Application to mitigate & regularise existing works

Lapford Mill group improvements : Planning Reference: PP-11662063

Prepared by Alex Gater, Applicant Owner, November 2022

Address: Lapford Mill House, Lapford,
Credon EX17 6PU
Scale drawing by A Gater
18 / 11 / 2022
22/02110/LBC
&
22/02113/HOUSE pp-11662063
Lapford Mill House

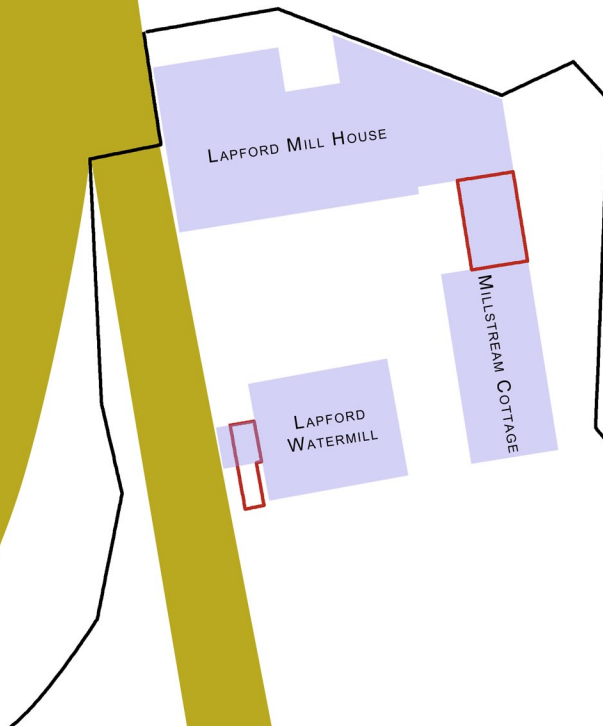
- a) Colour : Listings officer comment was to prefer a very dark brown or black, "as *would be common in the setting of listed building.*"
- b) Roof : Listings officer comment was to prefer a steeper pitch to the roof, that "*it appears rather strange set against the rear parapet wall, when viewed from the courtyard.*"

The current roof pitch and size are identical to the previous building however it was suggested by the listings officer that an 'enhancement' could have been applied when replacing this structure by increasing the roof pitch.

Having now consulted a professional builder, it was pointed out to me that the previous, rather shallow mono-pitch of the roof would have been necessary in order to join beneath the projection of the flat roof above the kitchen and accommodating rain goods. In heavy weather, a significant amount of run-off from the large flat kitchen roof is conducted there.

I am still awaiting a written quote / report from my builder, which I will forward when I have it. His advice is that increasing the pitch would also necessitate significant reengineering of the kitchen flat roof to either conduct rain run-off towards the rear of the house, or rebuild with rain gullies. Increasing the pitch would further reduce the available gap for run-off from flat roof to annex and in turn would also require changes to the kitchen flat roof as run-off from the large flat area would likely overpower current rain goods, which only just cope at present during heavier weather.

Given all the above, I would ask to be taken in to consideration that this annex does not change the look, size, materials or construction of the previous structure and although improvements could one day be sought across both roof structures, I would today seek to regularise the existing structure as is, postponing possible improvements together with the house kitchen roof for a future date.
